Rezoning Transportation Analysis

Petition Number: 2022-121

From: Jake Carpenter, PE
Jacob.carpenter@charlottenc.gov
980-221-5675

Date	Description
01-25-23	First Review (PDM)
02-22-23	Second Review (JP)

TECHNICAL DATA SHEET

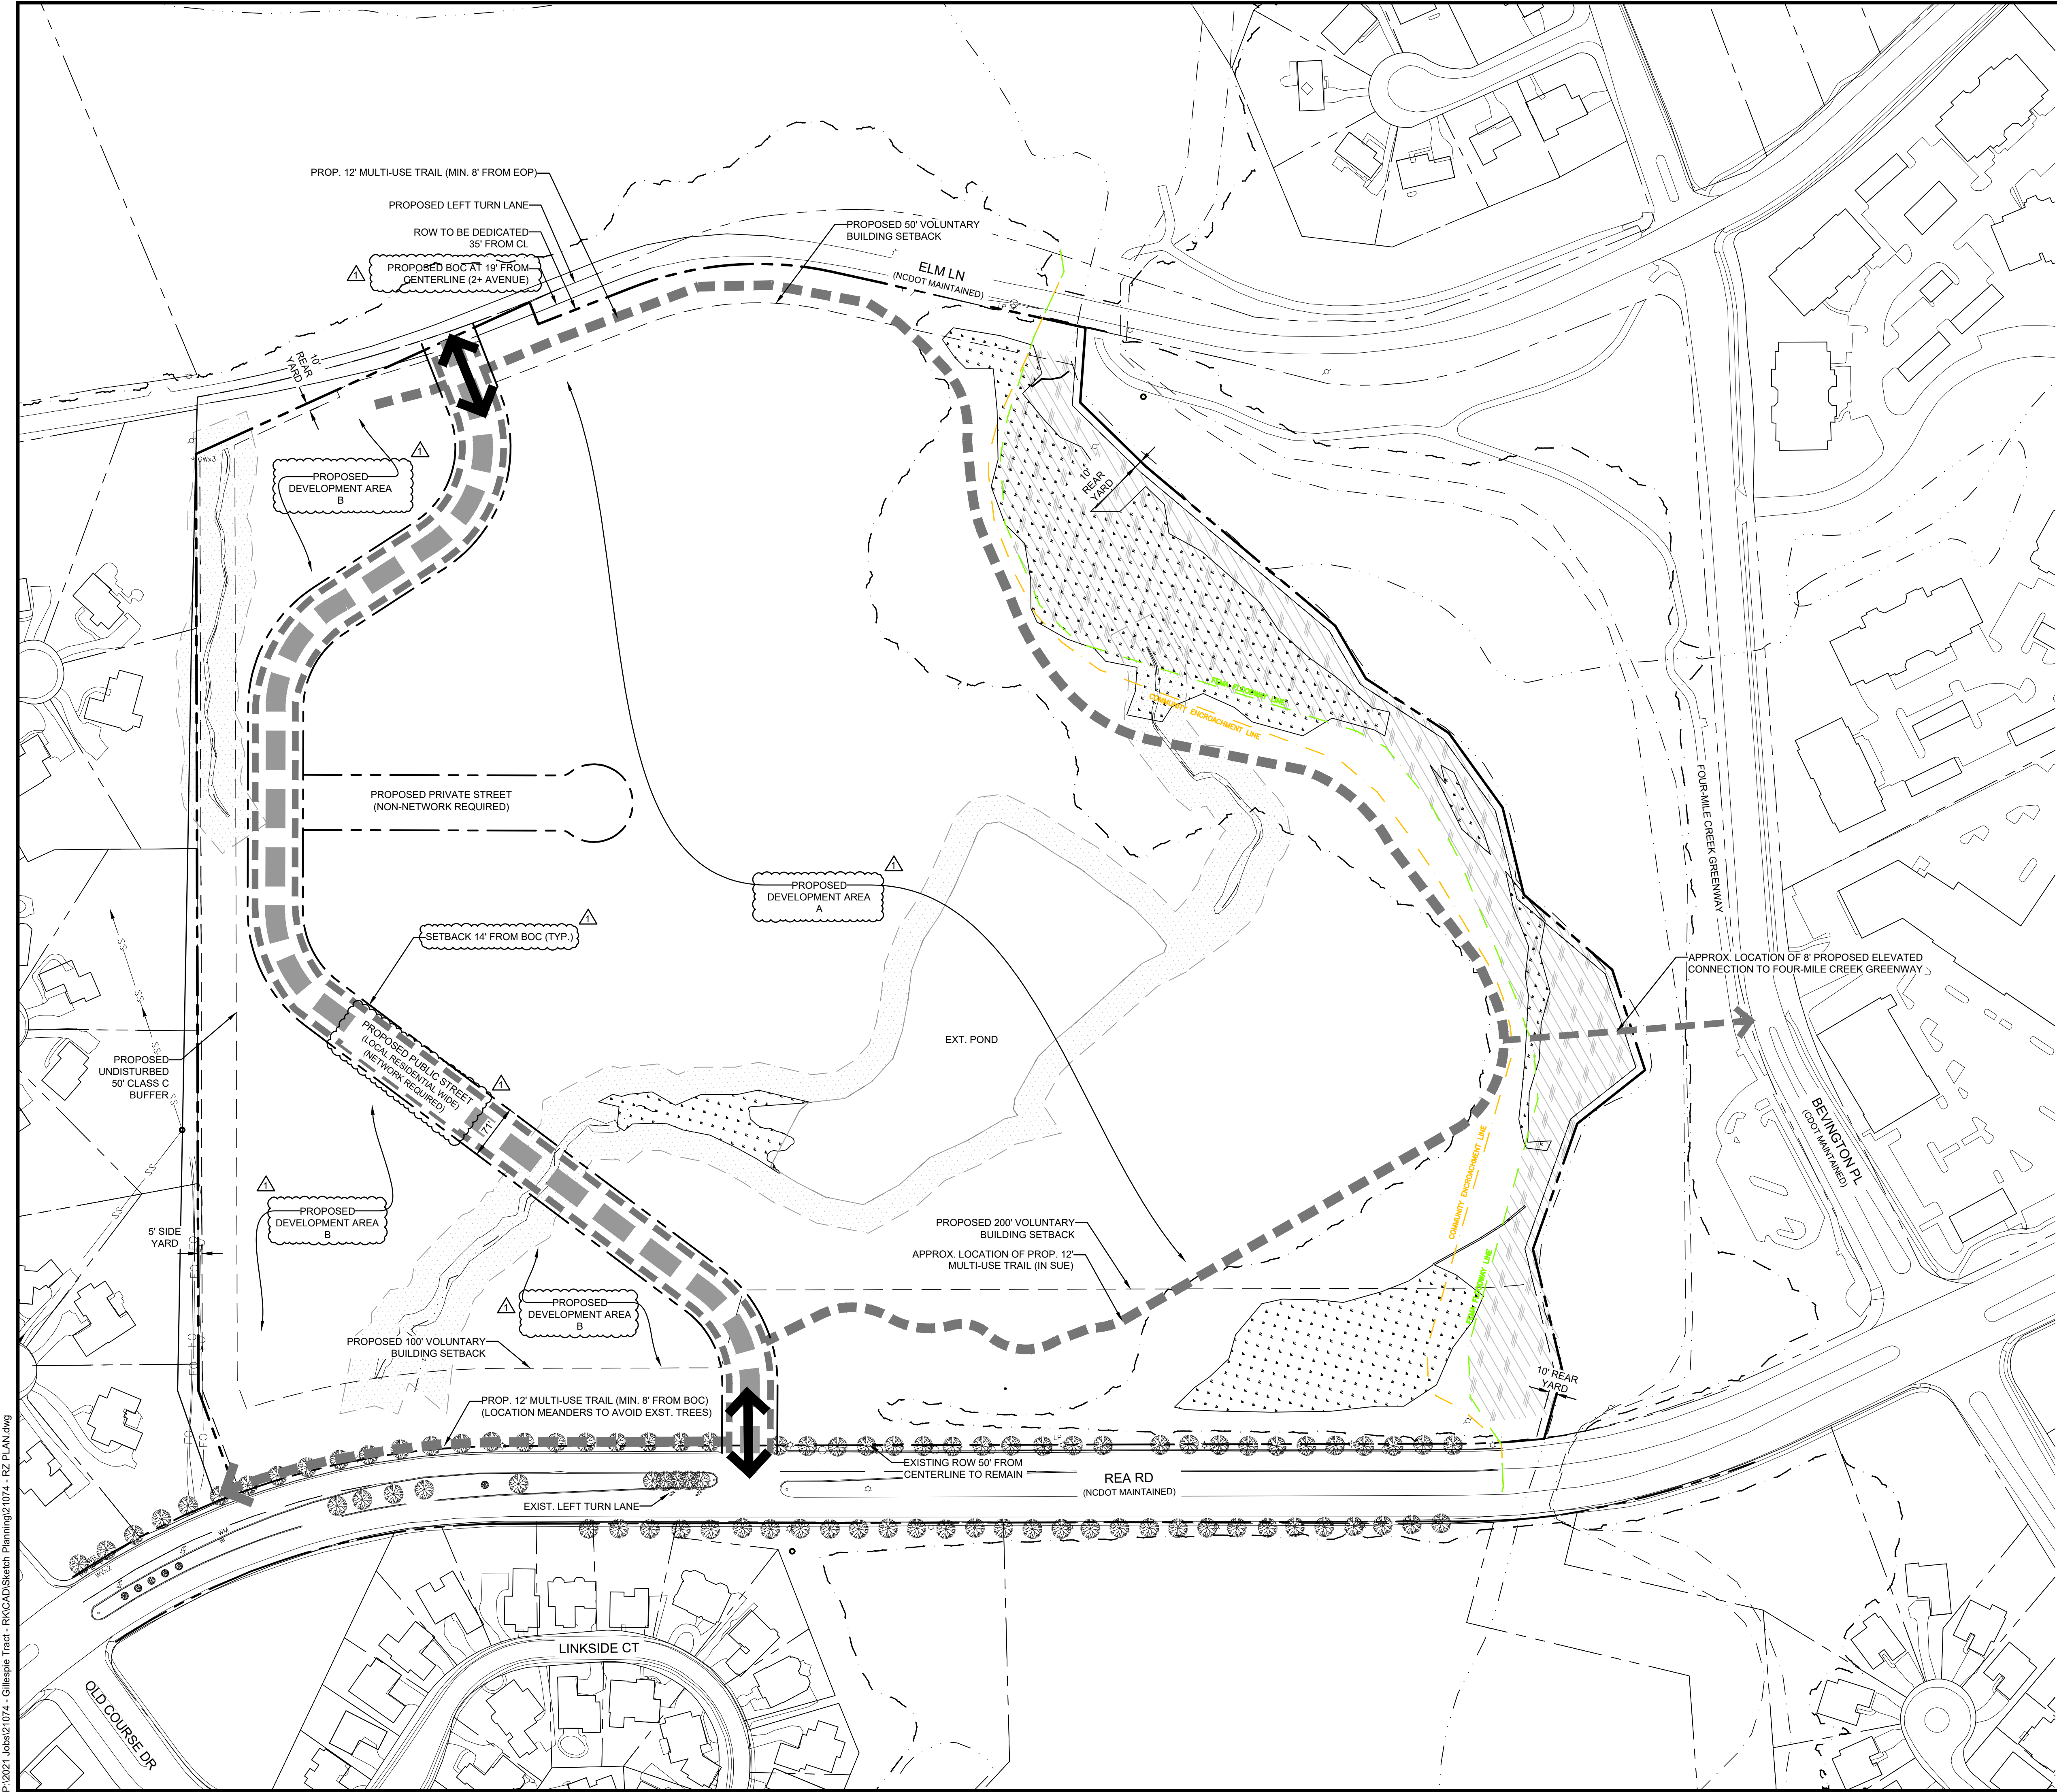
- ~~2. Revise site plan and conditional note(s) to commit to dedicate 35 feet of right of way from the road centerline of Elm Lane. The site plan shall label and dimension the right of way from the road centerline.~~
3. Revise site plan and conditional note(s) to commit to construct bicycle facilities by installing a 12' multi-use path along Rea Road to meet the Council-adopted Charlotte BIKES Policy. Multi-use paths maintained by the City shall meet ADA/PROWAG requirements. The multi-use path should provide a public onsite connection to the greenway. In addition, commit to providing public access easements for the onsite MUP connections along Rea Road and Elm Lane. For multi-use paths along the public streets, provide sidewalk utility easement located 2ft at back of path if located outside of the right-of-way. Reconcile these improvements with conditional note 6.C

Clarifying Comment from 2/22/2023: Show MUP along Rea Road as shown above. We can work through the technical aspects in permitting as well as any necessary adjustments or exceptions to the required path.

C. In lieu of the installation of an 8 foot wide planting strip and a 12 foot wide multi-use path along portions of the Site's frontages on Rea Road and Elm Lane, Petitioner shall install a 12 foot wide multi-use path within the Site that will traverse the Site from the new internal public street to Elm Lane as generally depicted on Sheet RZ-2 of the Rezoning Plan. This 12 foot wide multi-use path shall be located in a sidewalk utility easement. This 12 foot wide multi-use path shall be installed prior to the issuance of a certificate of occupancy for the 300th multi-family dwelling unit constructed on the Site.

D. An 8 foot wide planting strip and an 8 foot wide sidewalk shall be installed along both sides of the internal public street to be constructed on the Site.
